From: Simon Davis <Simon.Davis@arun.gov.uk>
Sent: 28 February 2020 16:35
To: Planning.Responses <Planning.Responses@arun.gov.uk>
Subject: FW: re; Pagham breaching the Spit planning application P/12/20/DOC

Further Natural England Consultation Advice

From: Marlow, Angela [REDACTED]
Sent: 27 February 2020 15:40
To: Simon Davis <Simon.Davis@arun.gov.uk>
Cc: Seymour, James [REDACTED]
Subject: RE: re; Pagham breaching the Spit planning application.

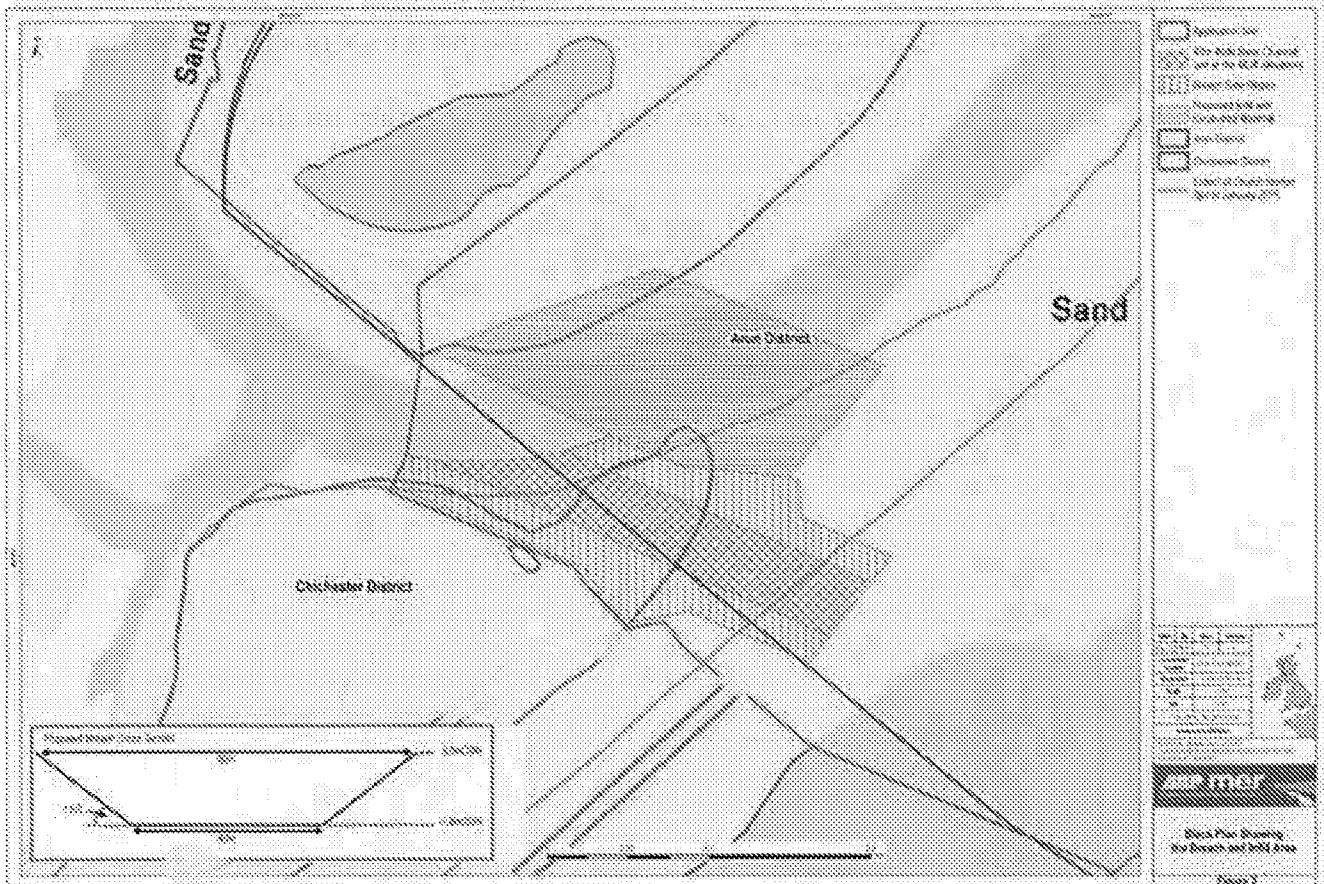
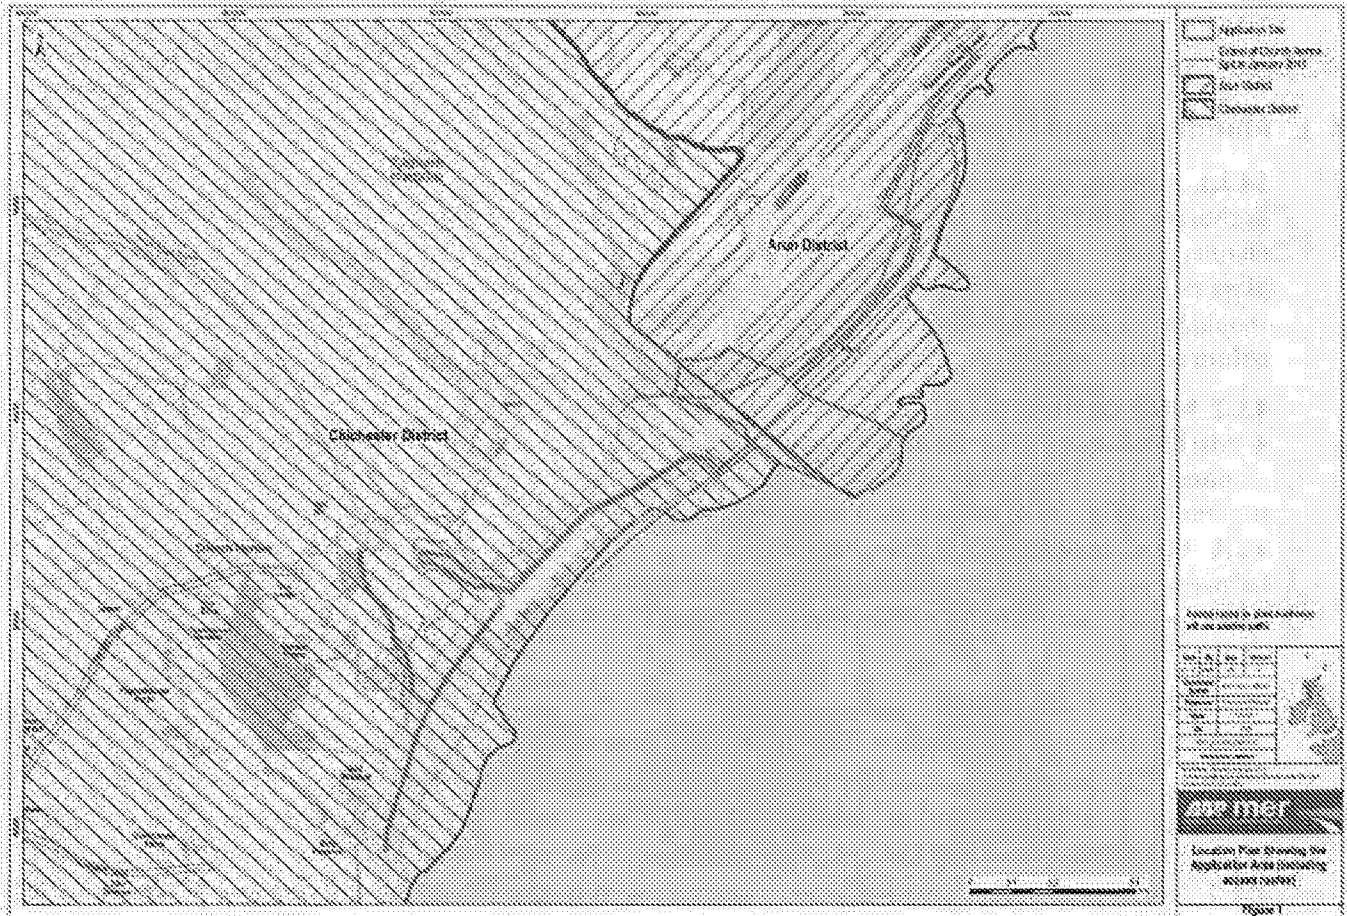
- 1) My comment about the CMP refers to the fact they have not provided this information for the construction of the breach when and if this takes place.
They have provided information for the CMP for the tern island construction only. And we have provided detailed comments on this.
Therefore we need the CMP detail for the breach activity, this maybe at a later date but before those work commence.
Apologies if this distinction was not clear.

These details only refer to the construction of the Tern Island, a separate plan will be submitted

should the main cut be made.
